WEST SUSSEX COUNTY COUNCIL CONSULTATION

TO:	Arun District Council FAO: Raymond Cole
FROM:	WSCC - Highways Authority
DATE:	15 December 2020
LOCATION:	Land West of New Barn Lane, Bersted, PO21 5DN
SUBJECT:	BE/119/20/PL 1 No. detached house. This site falls within Strategic Site SP2, CIL Zone 1 (Zero Rated).
DATE OF SITE VISIT:	N/A
RECOMMENDATION:	Advice
S106 CONTRIBUTION TOTAL:	N/A

CLIENT:	Bellway Homes Ltd (Wessex)	PROJECT:	Land West of Newbarn Lane, North Bersted
SCALE:	1:100 (A1 ORIGINAL)	DRAWING:	Plot 51 - Proposed Layout & Supporting Information
DRAWN: SA	18256	P201	—
DATE: Aug 2020

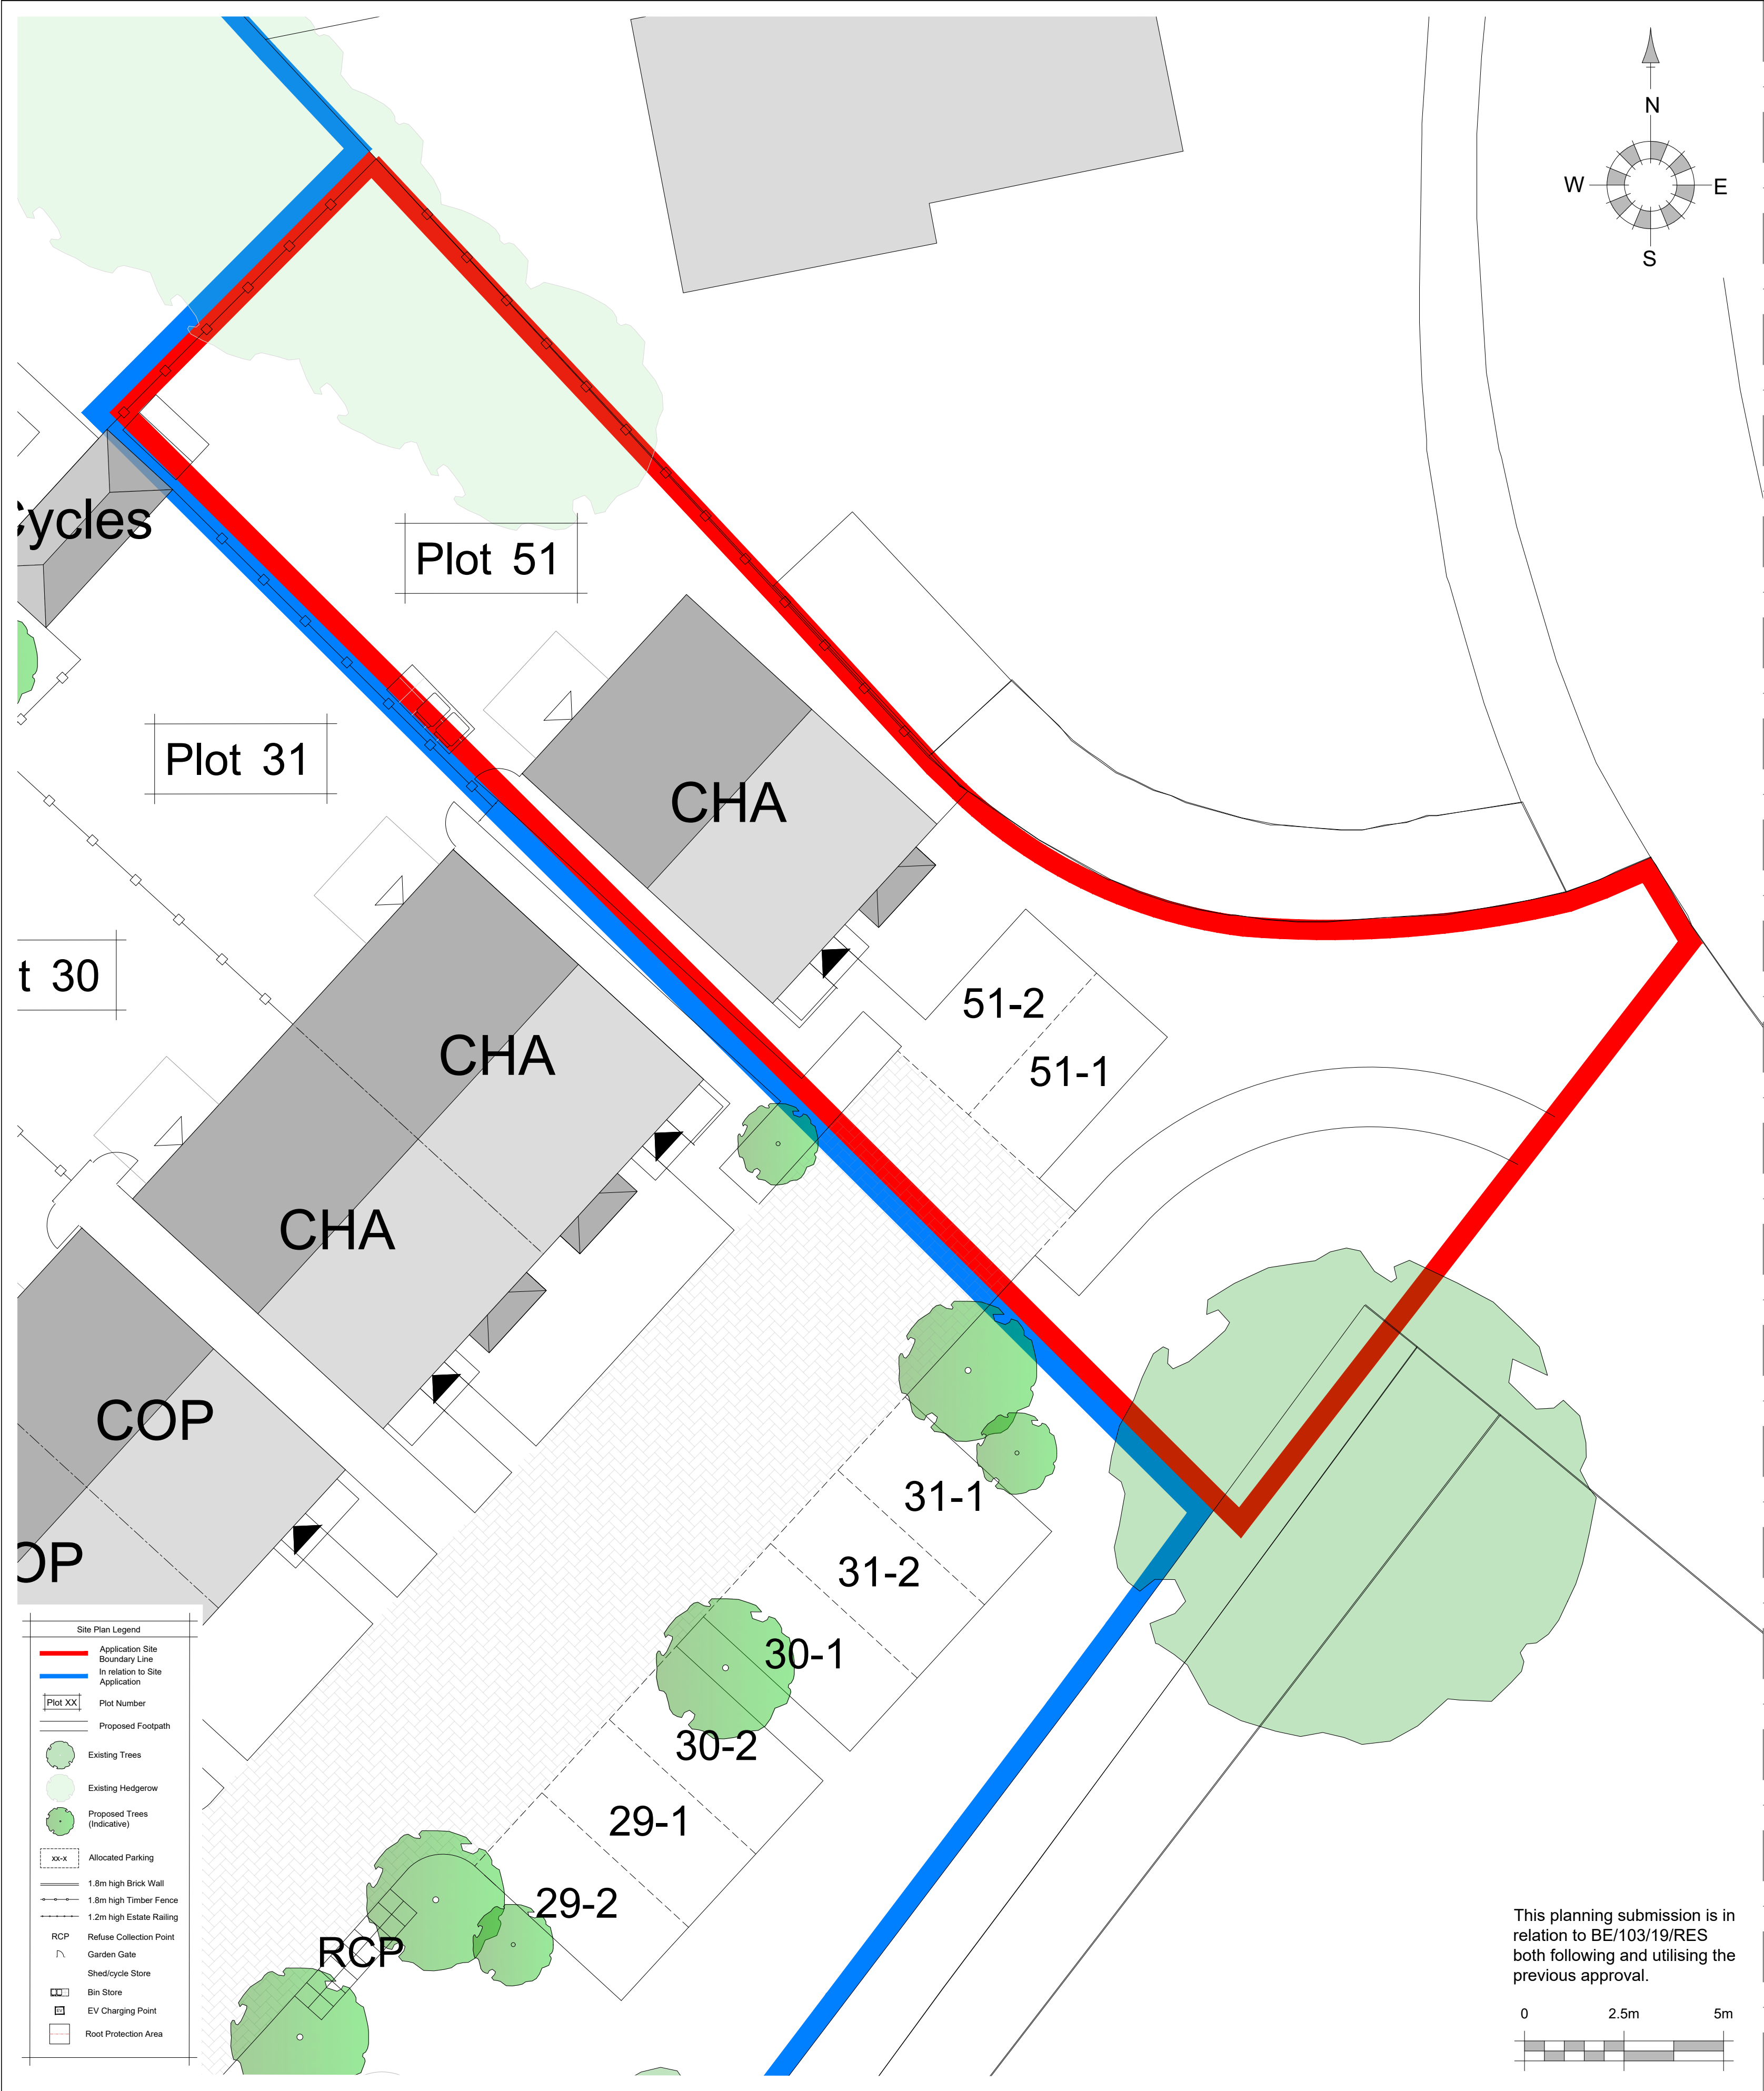
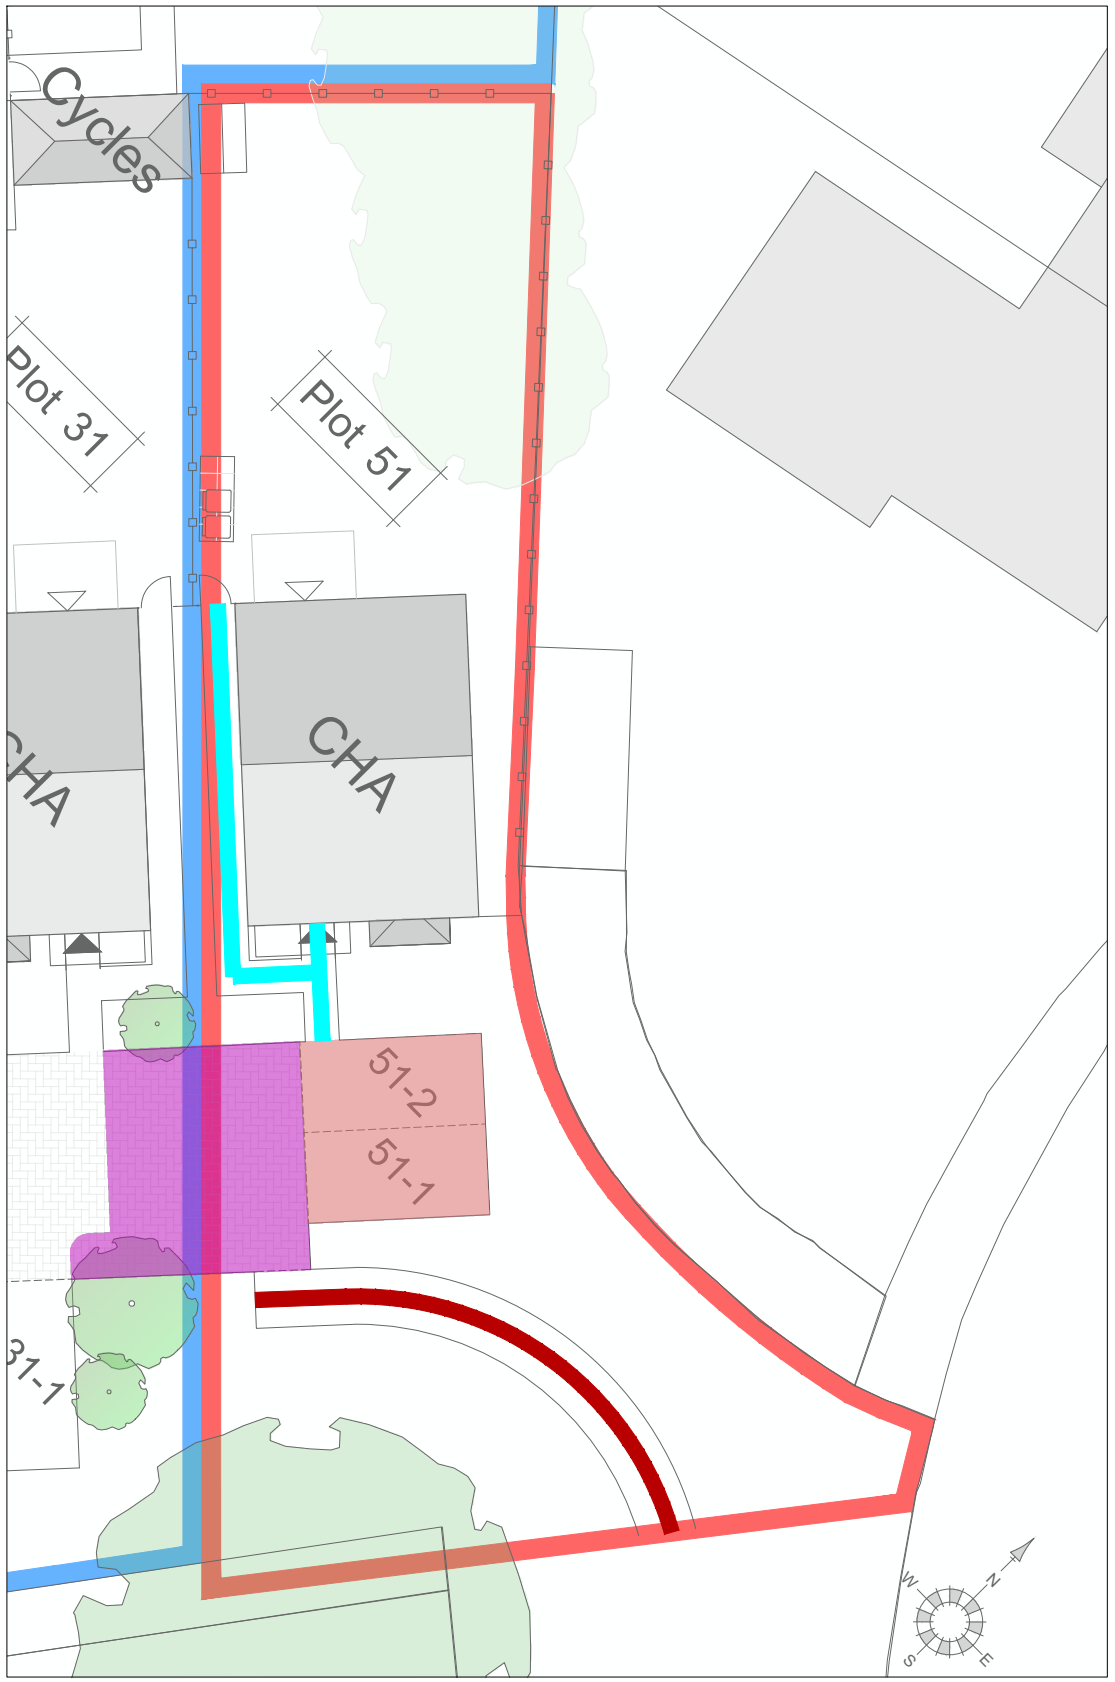
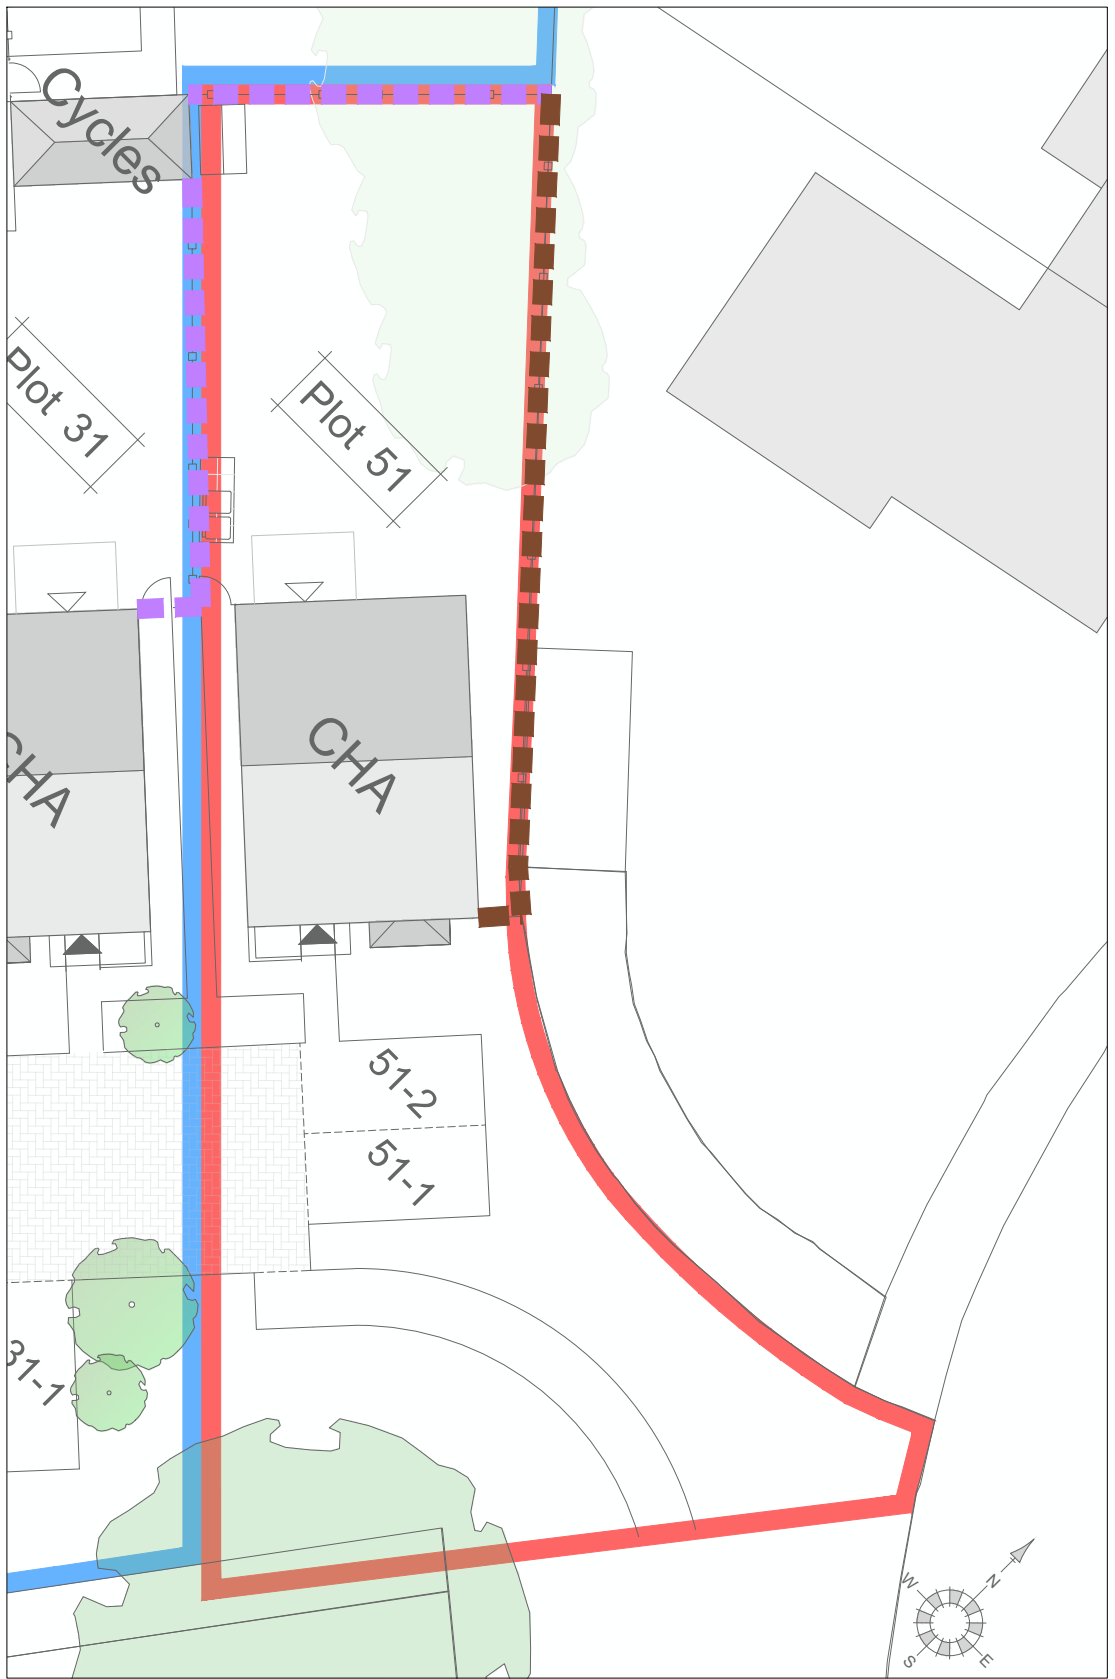
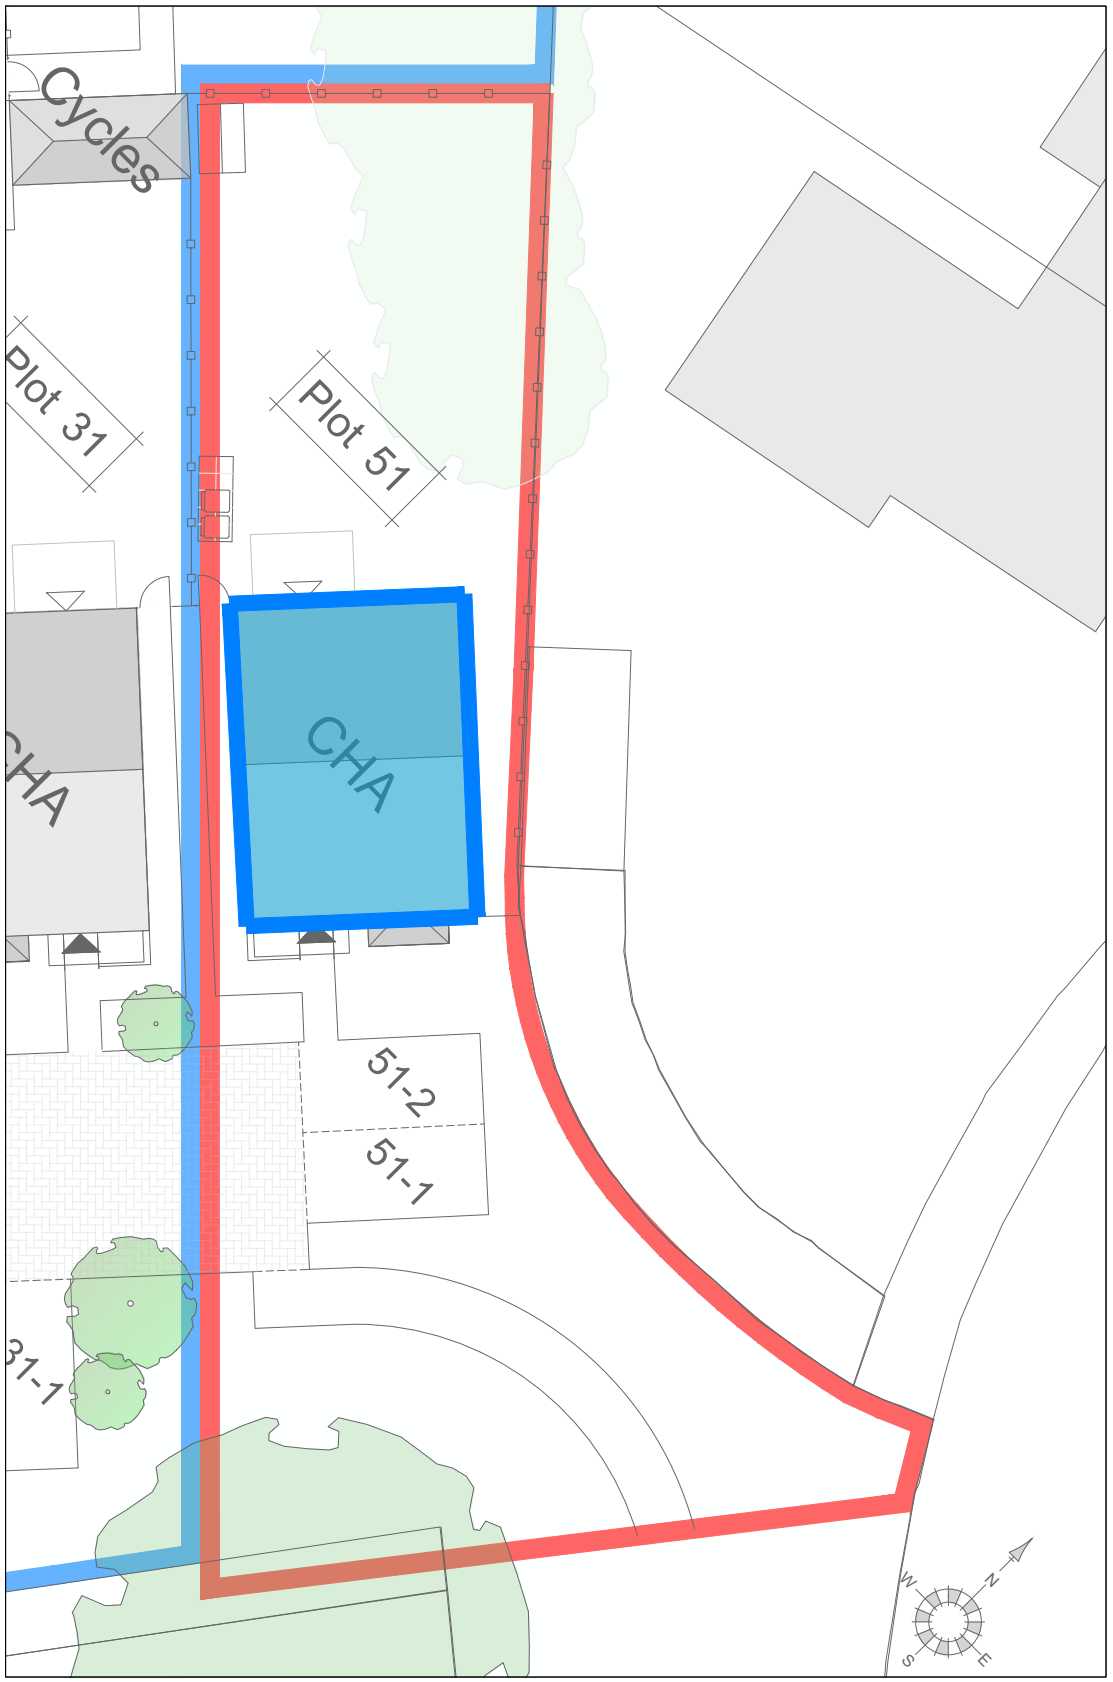
The applicant proposes a vehicular access at the end of Herdwick Lane. It is unclear if any works are proposed to cater for the two parking spaces. If the applicant does propose any access works, the LHA advises the applicant to consult the proprietor of the unadopted road to obtain formal approval for such works.

The applicant proposes two car parking spaces for this development. Under Arun Parking Standards (adopted January 2020), the LHA would anticipate that two car parking spaces would be sufficient for a dwelling of this size and location.

The LHA does note that on-site turning does not appear achievable. As such, cars leaving the site may have to perform a turn in the road in order to exit the development in a forward gear. However, given the sites location, this is not anticipated to result in a severe highway safety concern.

Regarding cycle parking, the applicant proposes a cycle store to the rear of the plot, with provision for two cycles. This is in accordance with WSCC parking standards for a dwelling of this size. The inclusion of secure and covered cycle parking helps promote the use of sustainable transport methods.

No part of the development shall be first occupied until the car parking has been constructed in accordance with the approved site plan. These spaces shall thereafter be retained at all times for their designated purpose.

No part of the development shall be first occupied until covered and secure cycle parking spaces have been provided in accordance with plans and details to be submitted to and approved by the Local Planning Authority.
